August 2, 2021
Ron Bohannon
Tierra West, LLC
5571 Midway Park Place, NE
Albuquerque, NM 87109

**Re: M&B Investments LTD Co. - 7200 Bluewater NW
Erosion and Sediment Control Plan
Engineer's Stamp Date Missing (K10E060)**

Based upon the information provided in your submittal received 7/26/2021, the above-referenced ESC Plan can not be approved for Building Permit until the following Comments are addressed. The comments are numbered the same as in the previous review sent 5/11/2021. Seven of the original 11 comments still need to be addressed including 2, 4, 5, 6, 7, 9, and 11.

ENGINEER'S SEAL	7200 BLUEWATER RD ALBUQUERQUE, NM	DRAWN BY pm
	EROSION CONTROL PLAN	DATE 7-20-21
		DRAWING 2020056-SWPPP
	TIERRA WEST, LLC 5571 MIDWAY PARK PL NE ALBUQUERQUE, NEW MEXICO 87109 (505) 858-3100 www.tierrawestllc.com	SHEET # SW-1
RONALD R. BOHANNAN P.E. #7868		JOB # 2020056

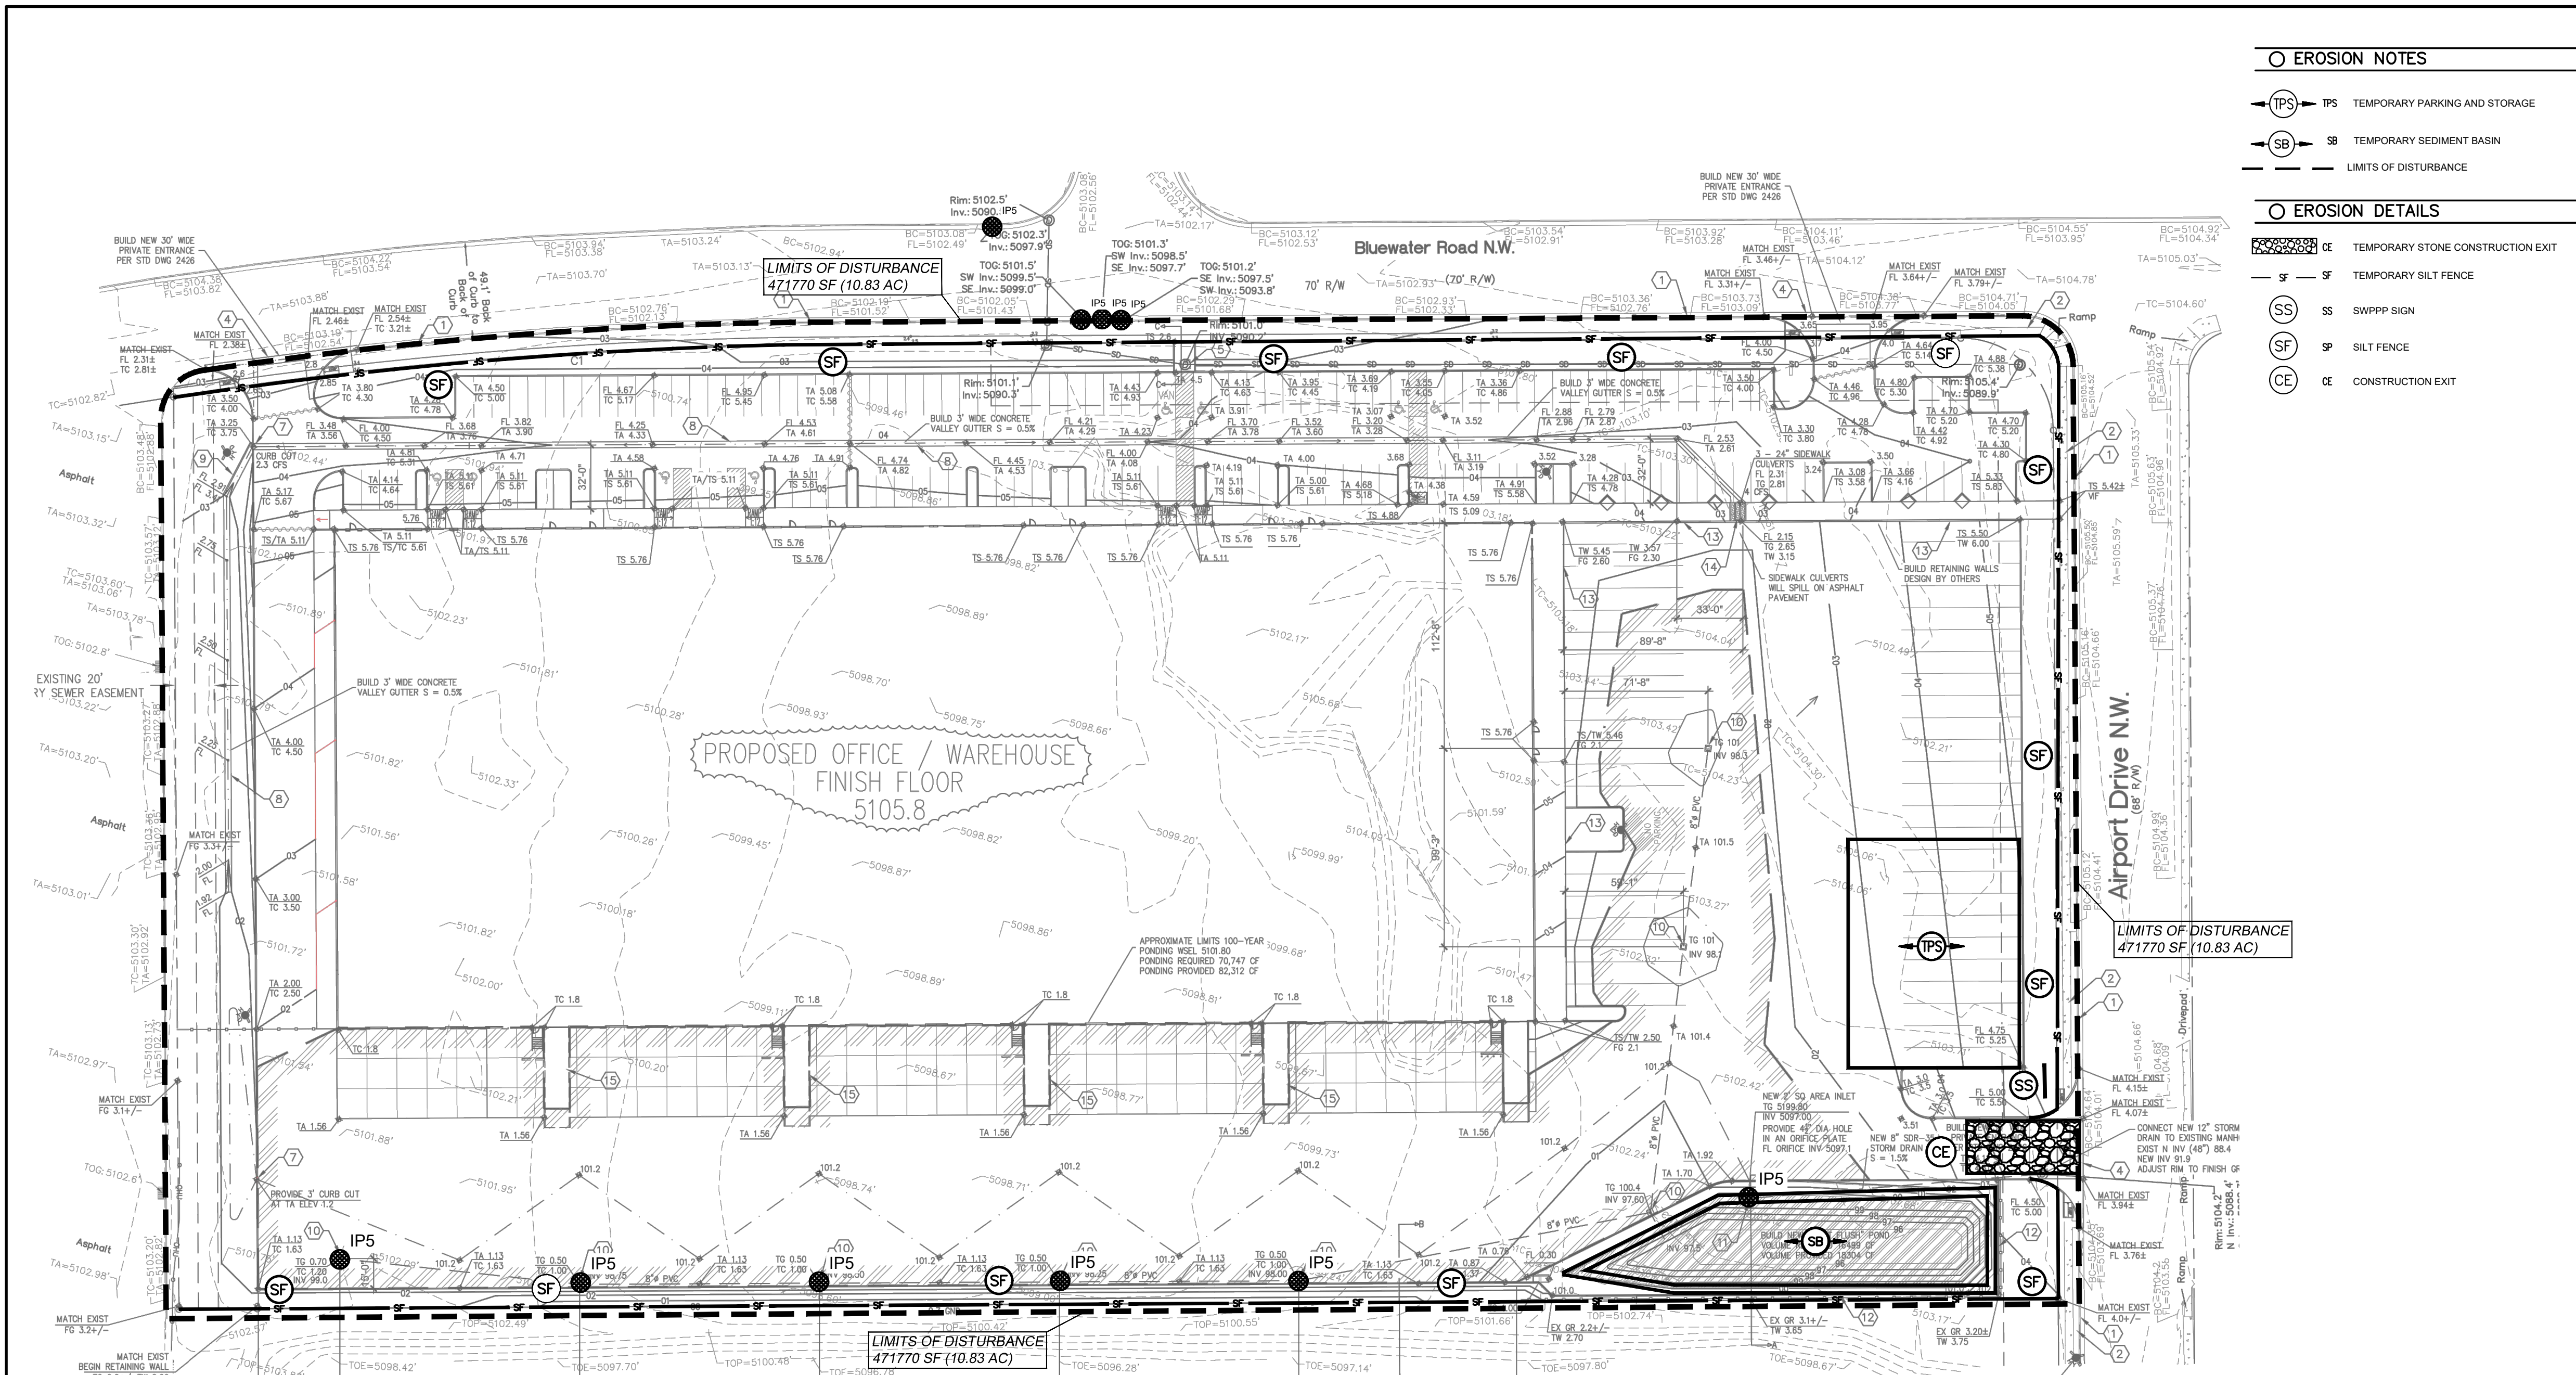
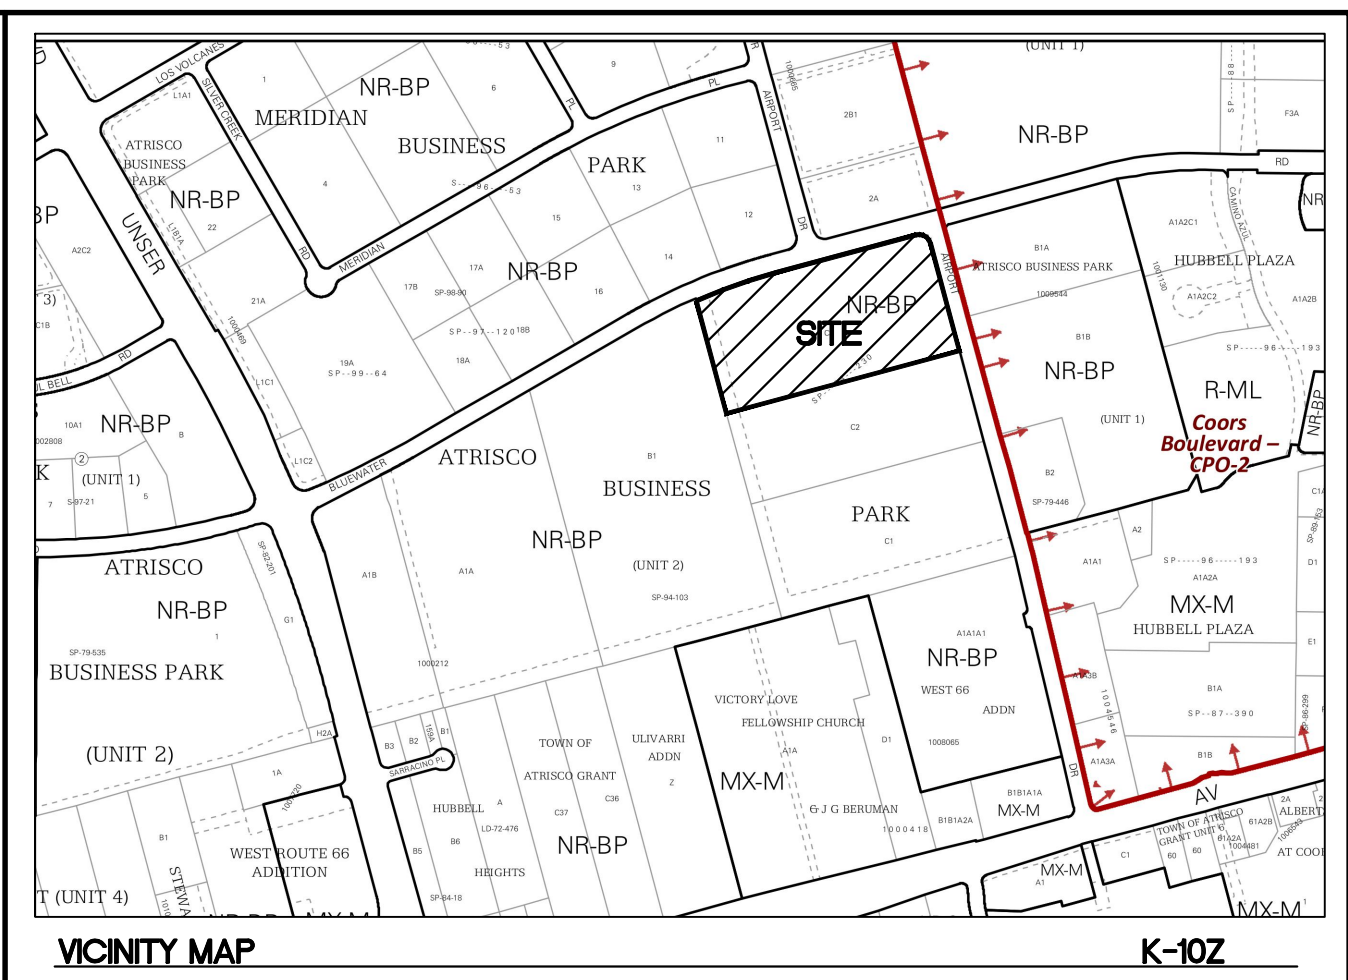
3. Undisturbed and pre-construction ground cover is described on sheet SW-1.
4. Operator #1 on sheet SW-1 is "Brunacini Development Ltd Co" which does not agree with the Operator permitted by NMR1003UT "GA Brunacini Construction Co. Inc." and neither agree with the property owner of record "M&B Investments LTD Co." The latter two seem to identify the Contractor and the Property Owner both of whom need an NIO and both should be identified on sheet SW-1 along with the area of control of each.

5. This site has been in operation now for three months so the four SWQ Team members required by CGP 7.2.2 should be clearly understood and should already be well documented in the SWPPP. Identify the following team members on the ESC Plan sheet SW-1 and provide proof of training certificates.

- d. Personnel who are responsible for taking corrective actions as required in Part 5.
6. The "Nature and Extent of Construction Activities" on sheet SW-2 doesn't include the building or landscaping. The Schedule on sheet SW-1 also omits the building and the landscaping and talks about onsite roadway and installation of additional silt fence to

8. The soils information has been added to sheet SW-2
 9. The Engineer's stamp is missing. It is required by CGP 9.4.1.c.iii .
 10. The City Standard notes have been added to sheet SW-2

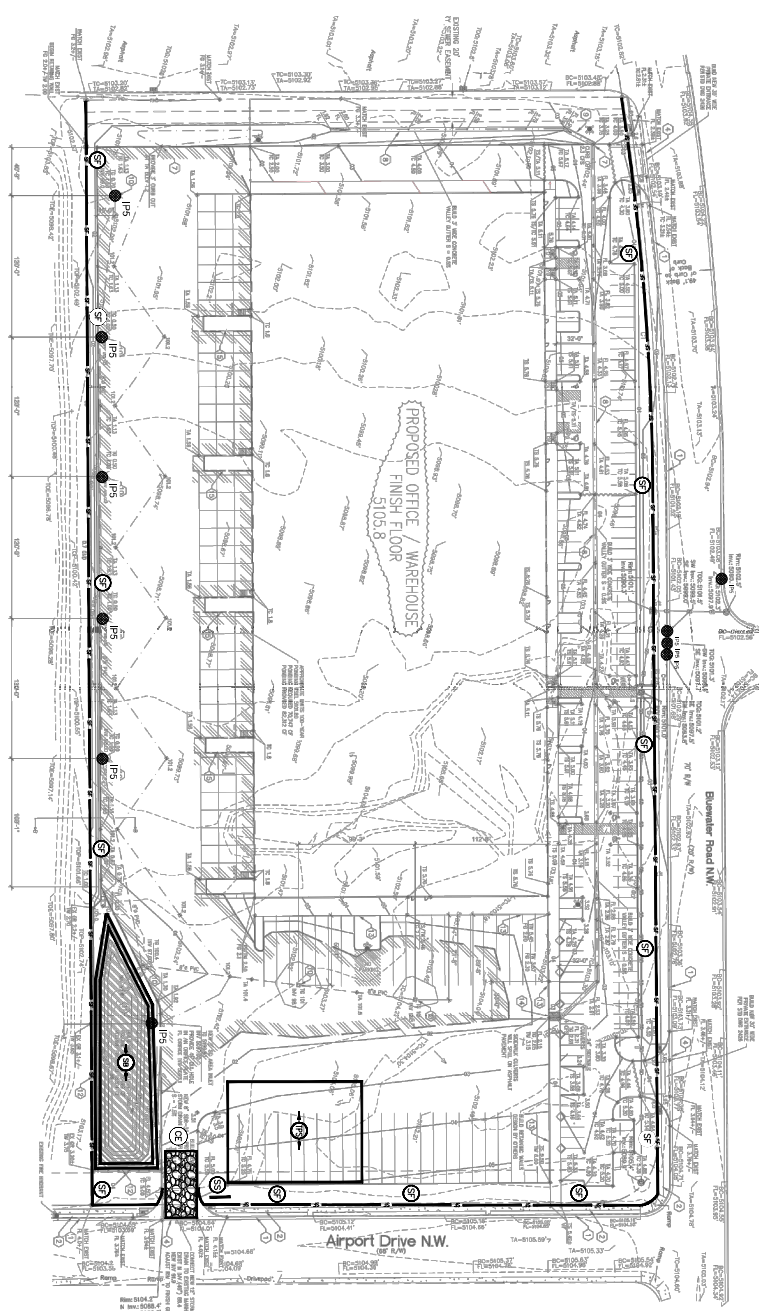
- keep sediment out of onsite roadways which seems to apply to a totally different project. The description of Construction Support Activities may be omitted unless those areas of land-disturbance will occur off-site in which case the areas must be shown on the plan. Delete the paragraph that calls for annual inspections and replace it with the inspection frequency required by the CGP. Delete the sentence that says an NOI may be transferred since that is specifically prohibited by CGP Appendix I.12.3.
